**Laurie Leader - Re: BP#2014-023767 Newbury Street - Plan review questions**

I am handling the plan review for 73 Newbury Street. Can you please clarify the following:

ABYSSINIAN MEETING HOUSE  
WEST EAVE WILL CHANGE

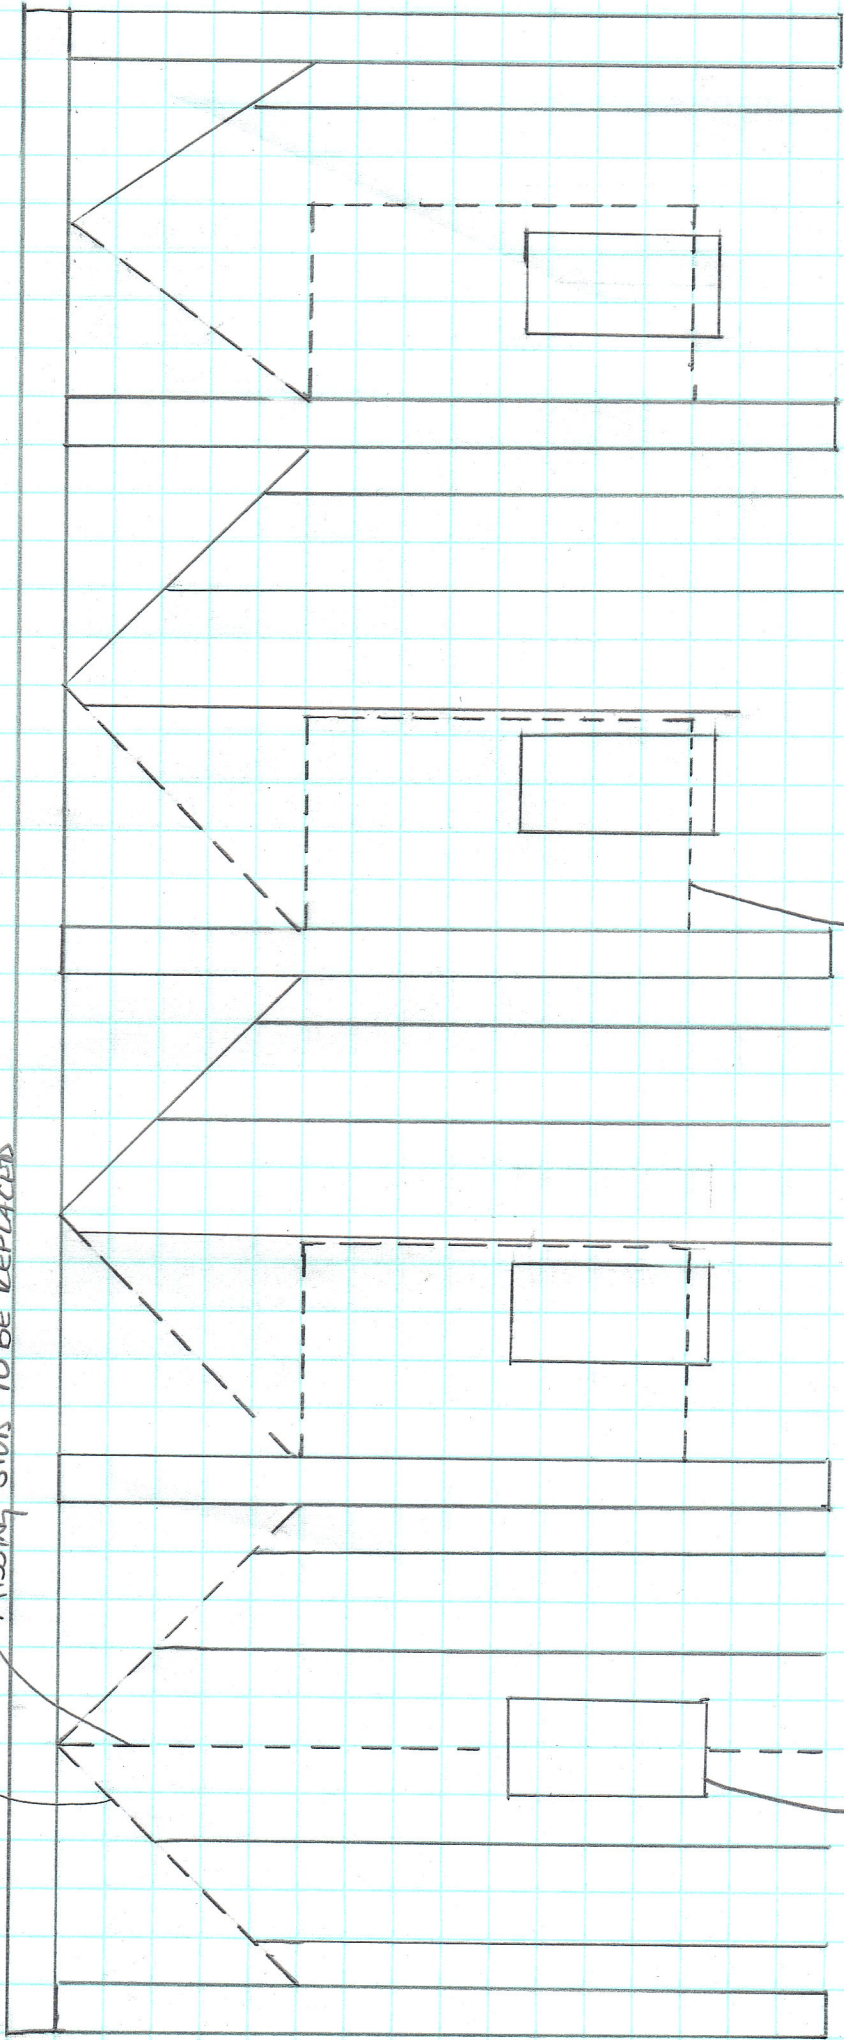
1. Is the use of the building going to be a museum/meeting house or a church/community center?
2. Are windows being installed in the rough openings?
3. Can you clarify what the interior demolition consists of? The plans do not reflect any interior demolition.
4. Can you provide dimensions on the plans for the proposed rough openings?

When the project is complete it will ultimately be used as a museum and community center. During this phase of work there will not be any windows installed, just the rough openings made and then sealed off for windows at a later time.

The rough opening for the windows is 4'x8', this is based on the evidence found during our previous demolition and to match that of the windows in the front gable.
